Date: 06 December 2013
Our ref: 103282
Your ref: BR/272/13

Planning consultation: Construct a replacement launching ramp on the beach

Location: Beach adjacent Bognor Regis Yacht Club Victoria Road South Bognor Regis PO21 2NA

PROPOSED REPLACEMENT RAMP AT BOGNOR REGIS YACHT CLUB

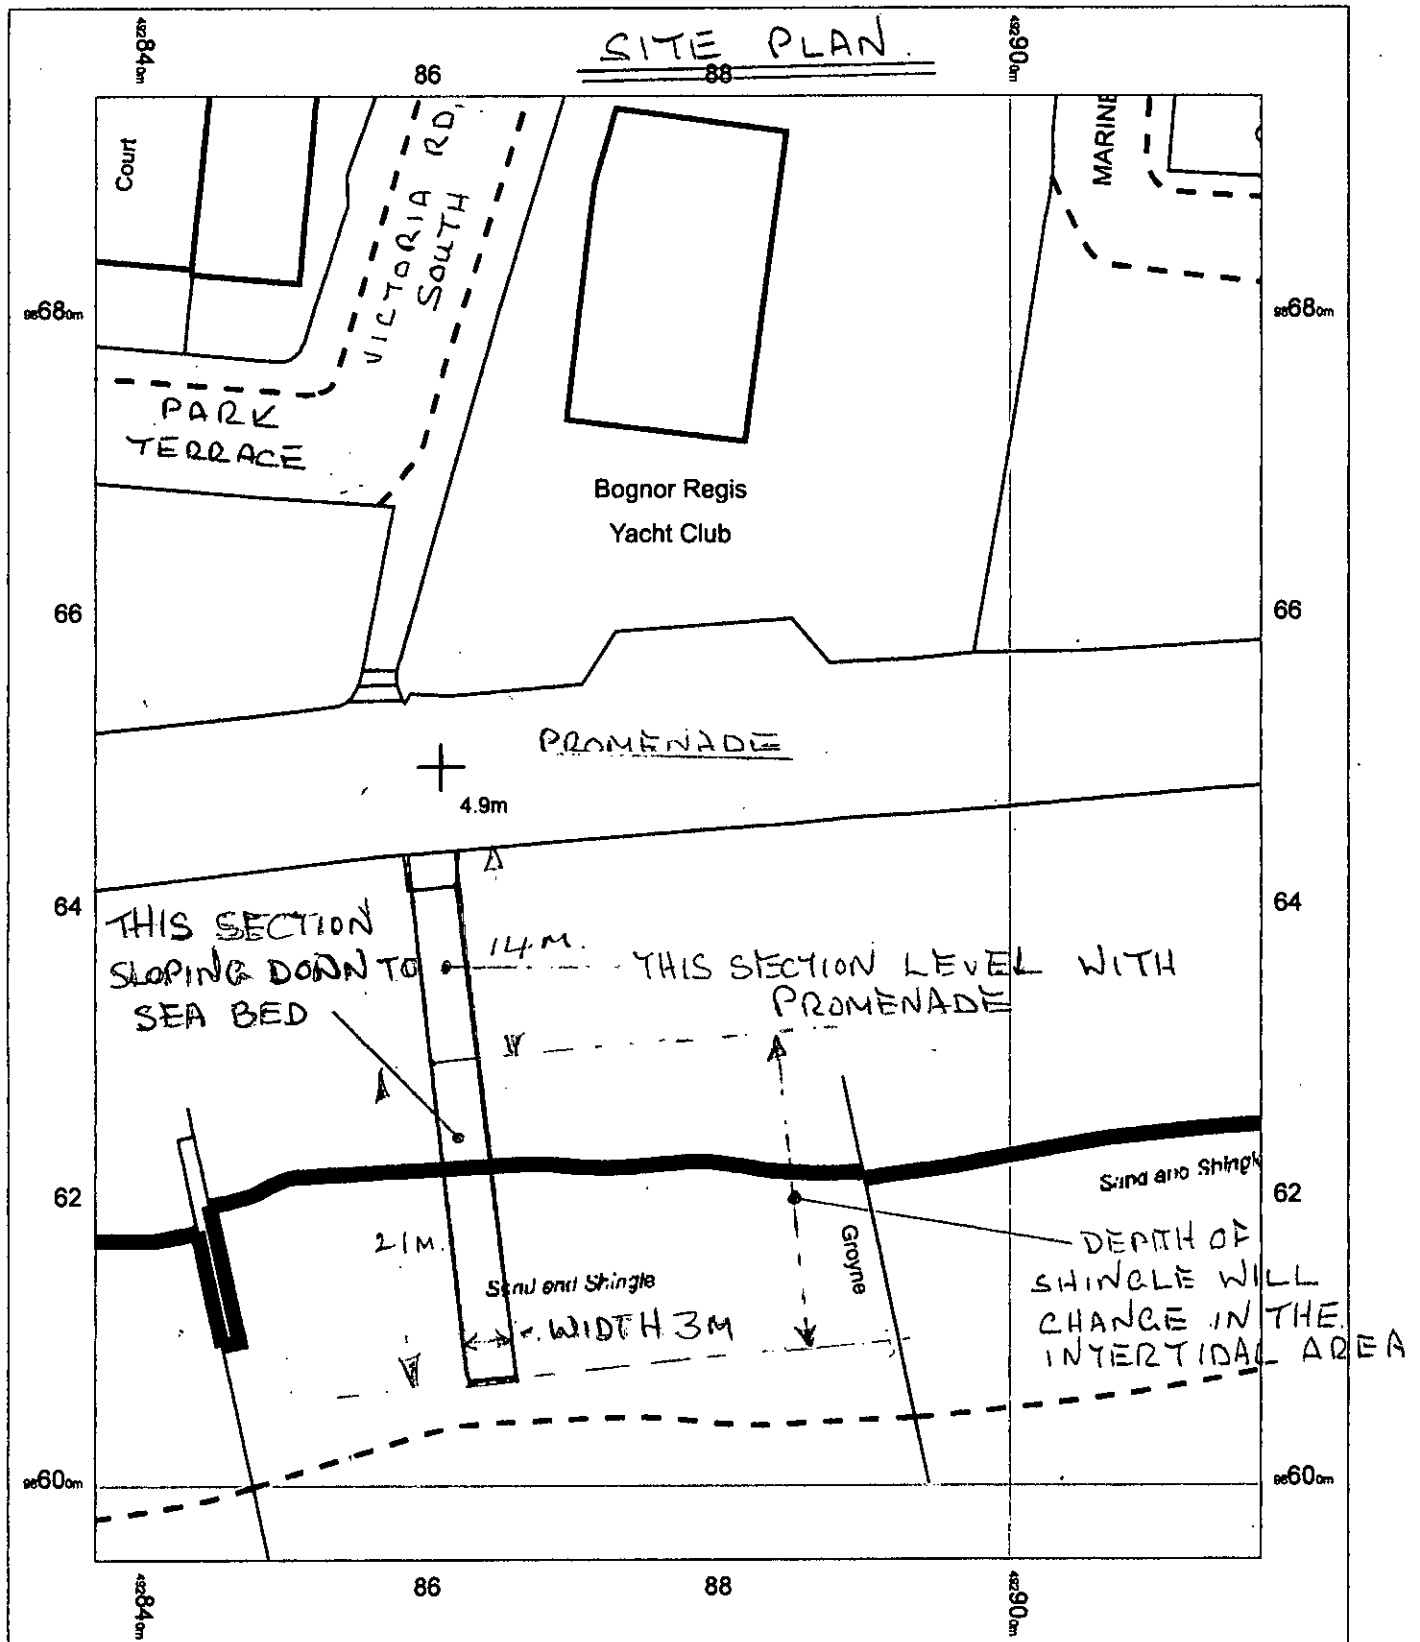
1. The ramp is to extend no further than the nearby outfall pipe (see photo in annex 1) in order to avoid impacting the movement of natural sediment.
2. Storage of plant machinery and equipment to be outside of the SSSI (i.e. on hard standing and not on the shingle beach).
